City of Albuquerque

RE: DESERT SPRINGS CHURCH (E-16/D21)
(705 Osuna NE)
ENGINEERS CERTIFICATION FOR CERTIFICATE OF OCCUPANCY
ENGINEERS STAMP DATED 12/5/2001
ENGINEERS CERTIFICATION DATED 9/27/2002

**RE: Grading and Drainage Plan For Desert Springs Church (E16-D21) Dated
December 5, 2001 Revision July 18, 2002**

**RE: Grading and Drainage Plan For Desert Springs Church (E16-D21) Dated
November 14, 2001**

SHEET TITLE	SHEET NO.
GRADING PLAN	C3.0

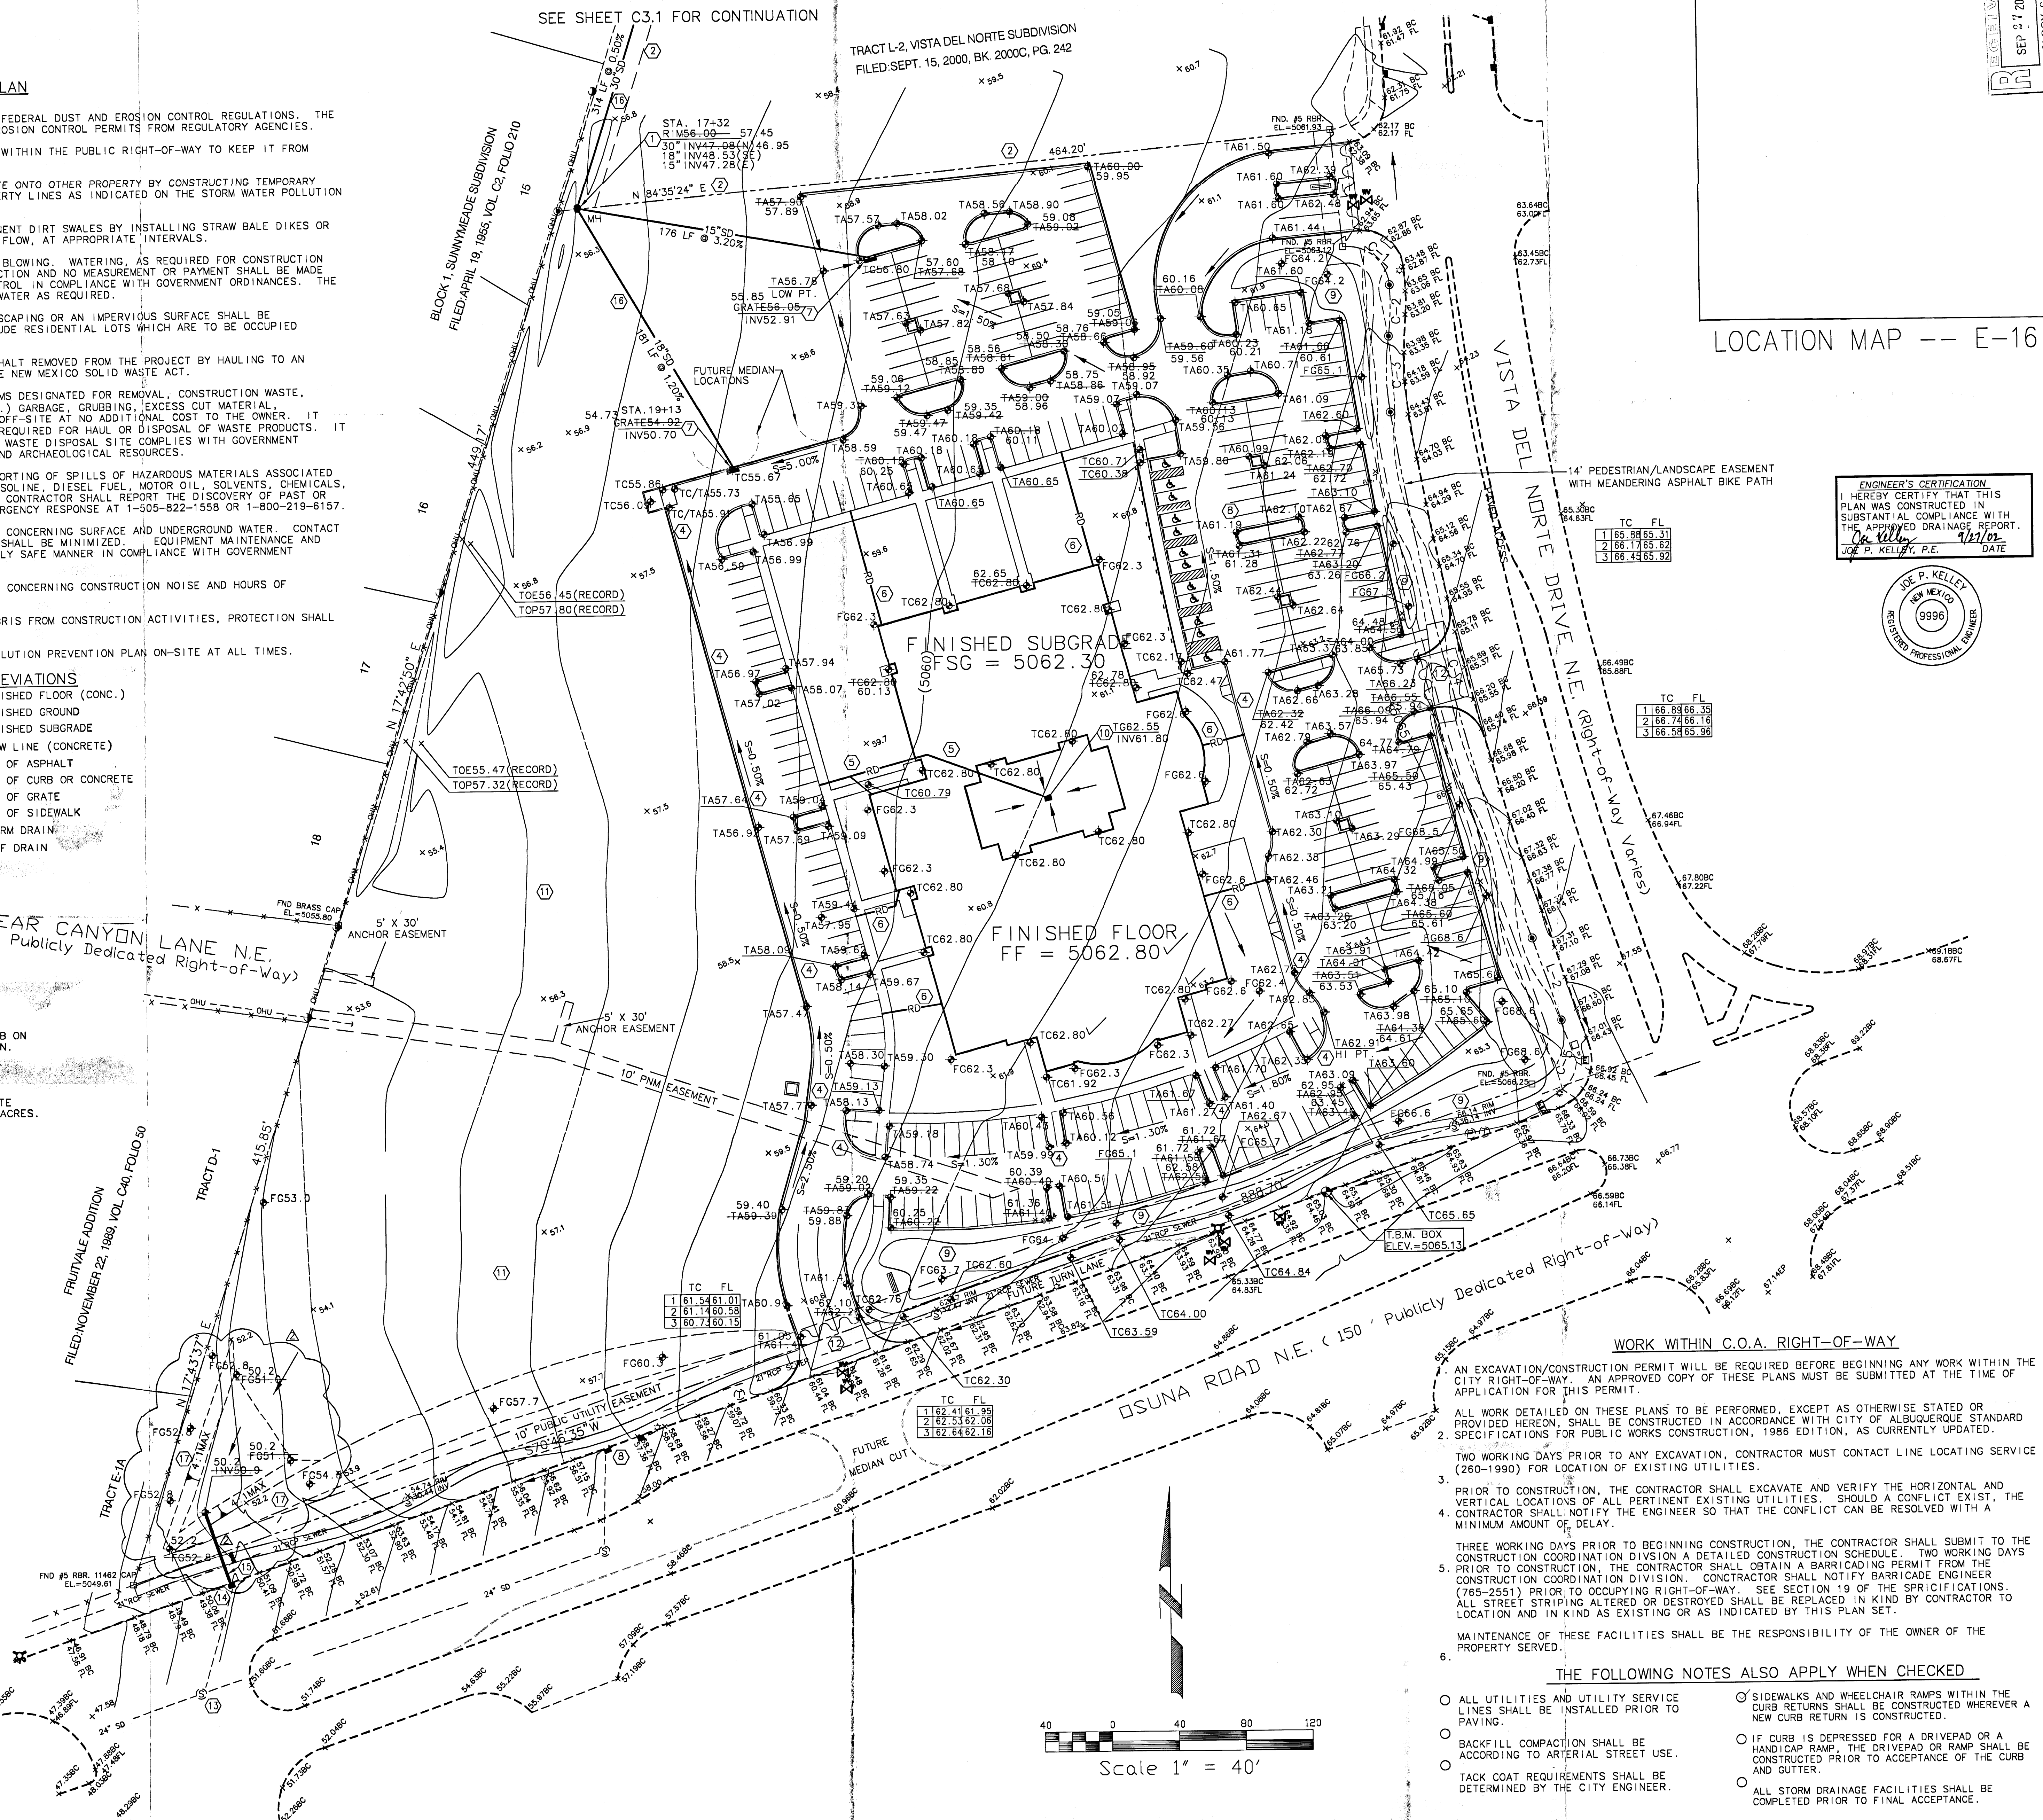
1. Please submit the private drainage easement for tract L-2. We need to make sure that this is a viable option.
2. Please submit a plan and profile sheets for the proposed storm drain that is not constructed to see the grades and to see how much easement is needed. When will this storm drain be built?
3. Who will have to maintain this storm drain?
4. Please show the as-builts for the downstream drainage system.
5. Please design a small sediment pond for the runoff that is going to enter Osuna Road.
6. Does the ultimate capacity of the downstream capacity include the 48-inch storm drain from Vista Del Norte Drive?
